Rezoning Transportation Analysis
Petition Number: Insert Zoning Petition # 2021-031
General Location Identifier: Tax ID 15503211

Date	Description
03-25-2021	First Review (WB)

RZ1.00

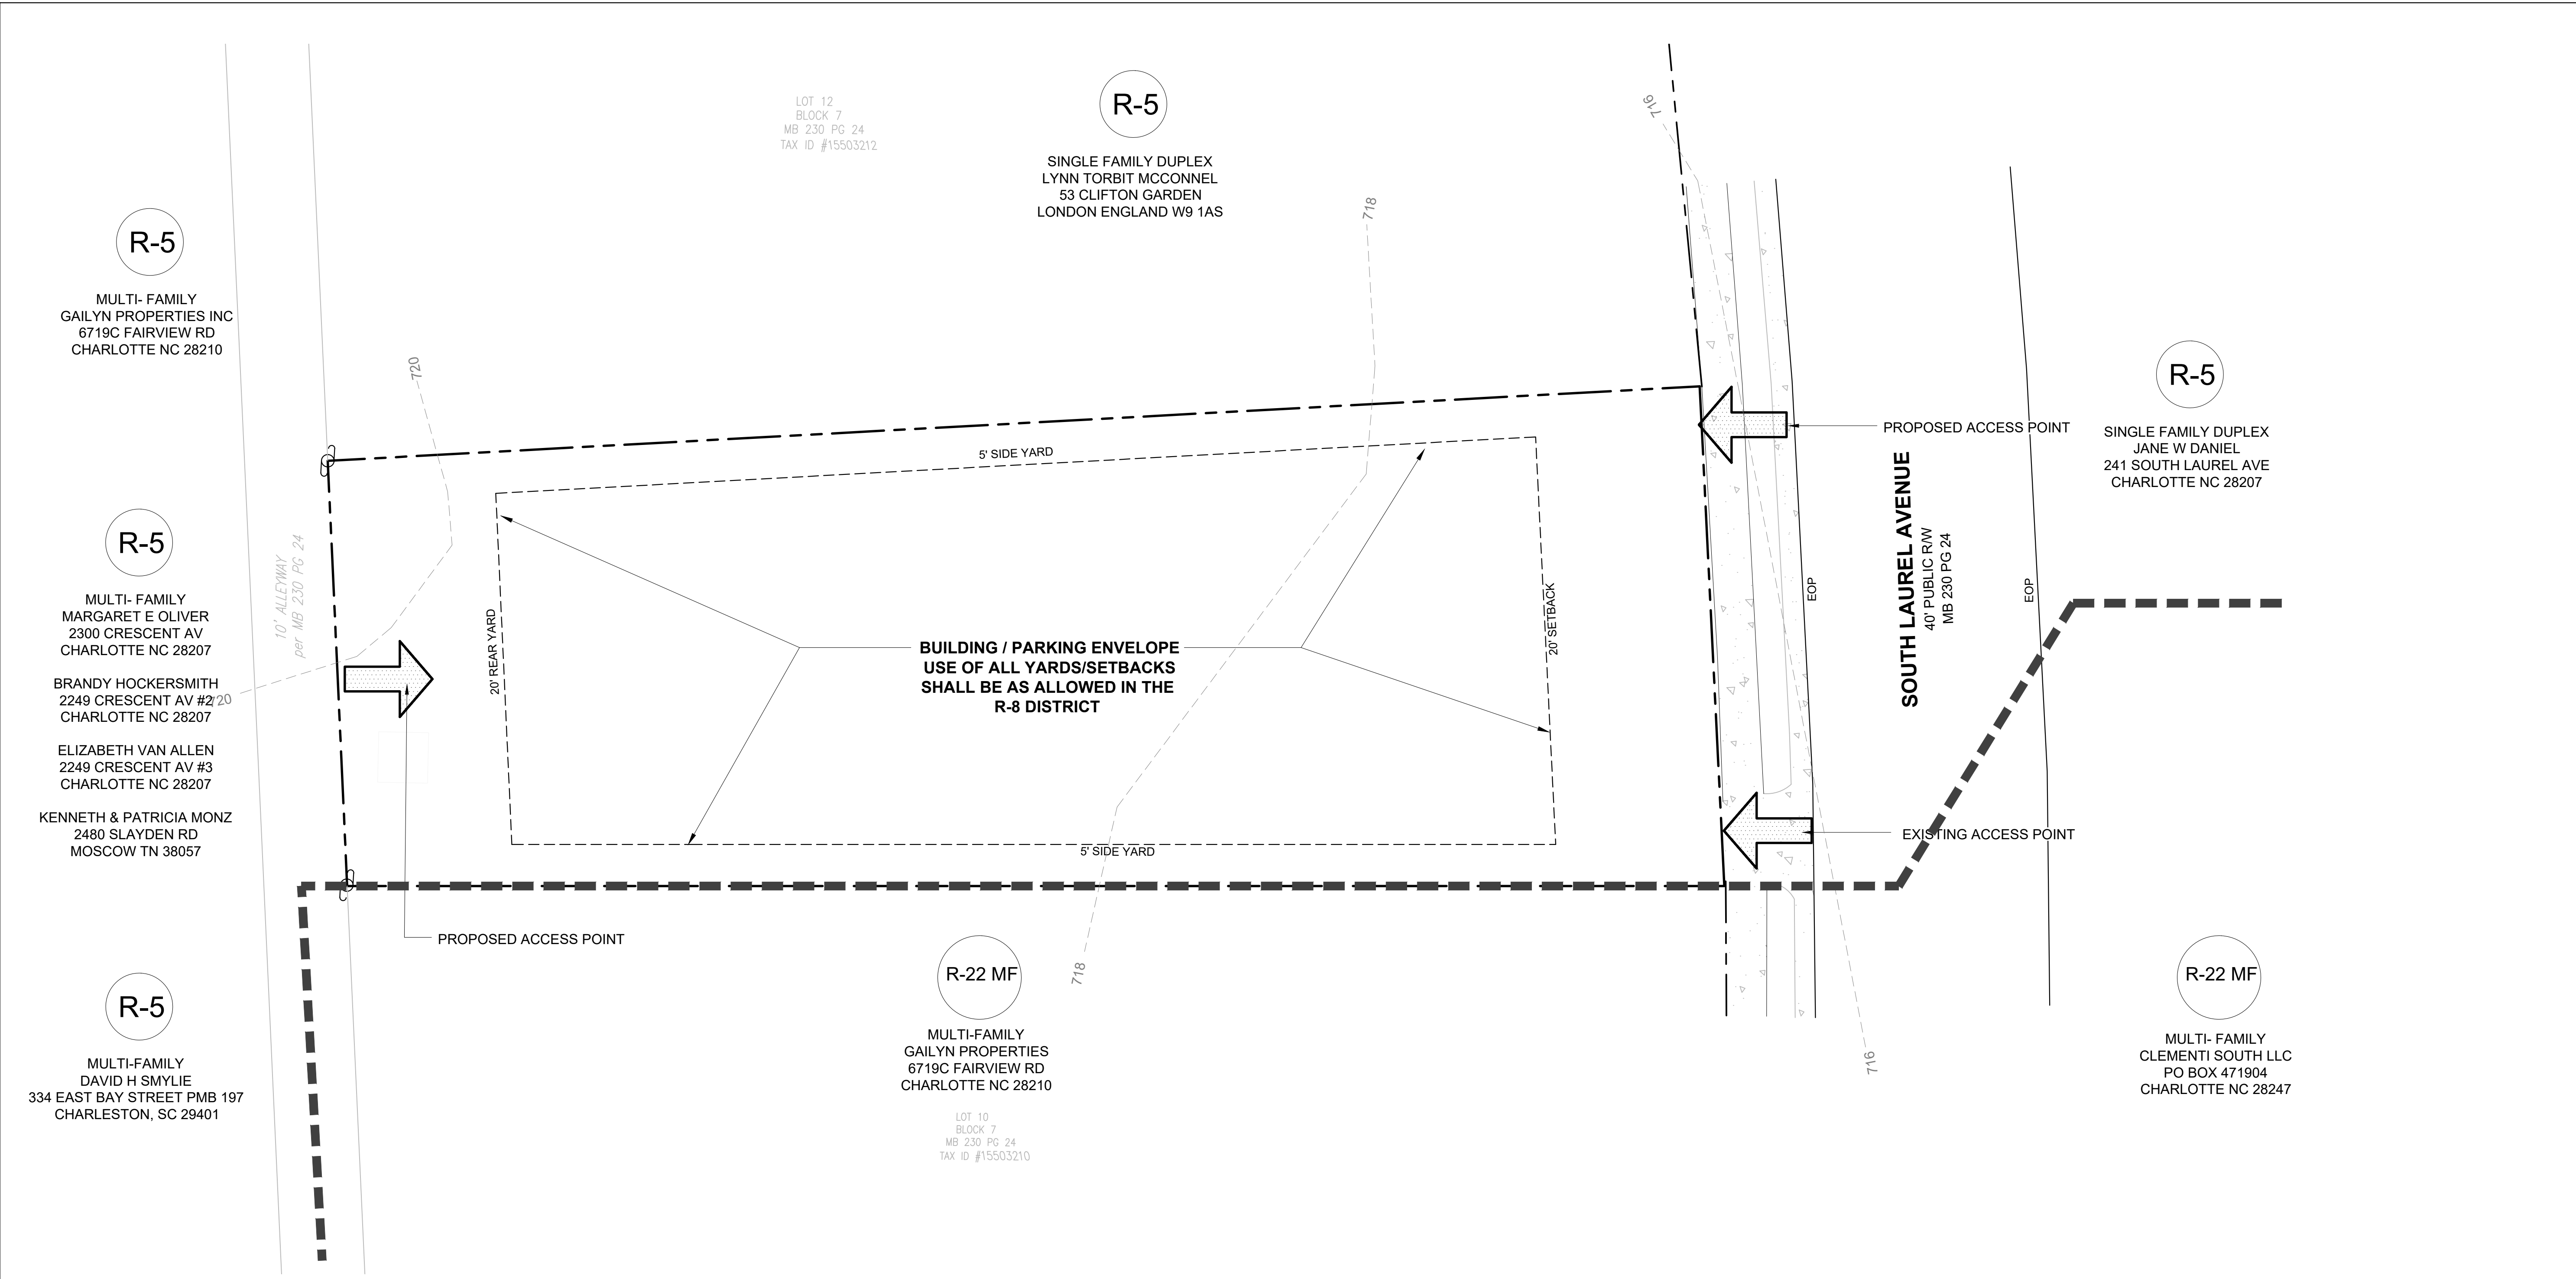
1. **Curbline:** The proposed zoning district has a setback measured from back of the existing or proposed future curbline.
 - a. **South Laurel Avenue:** The future location of curb and gutter is in its existing location.

Label and dimension the curb and gutter from the centerline for each road on the site plan.

3. Revise site plan and conditional notes to commit to dedicate 30' right-of-way from the road centerline. The site plan shall label and dimension the right-of-way from the road centerline.

4. Revise site plan and conditional notes to commit to construct a 6-foot sidewalk and an 8-foot planting strip on South Laurel Avenue per Chapter 19. The site plan shall label and dimension both items from the back of curb and gutter and road centerline.

5. There are existing and proposed driveway access points along South Laurel Avenue. Please show the minimum distance between the two site access points on South Laurel Avenue.
6. Add a site plan note specifying dedication and fee simple conveyance of all rights-of-way to the City before the site's first building certificate of occupancy is issued is needed. CDOT requests rights-of-way set at 2' behind back of sidewalk where feasible.
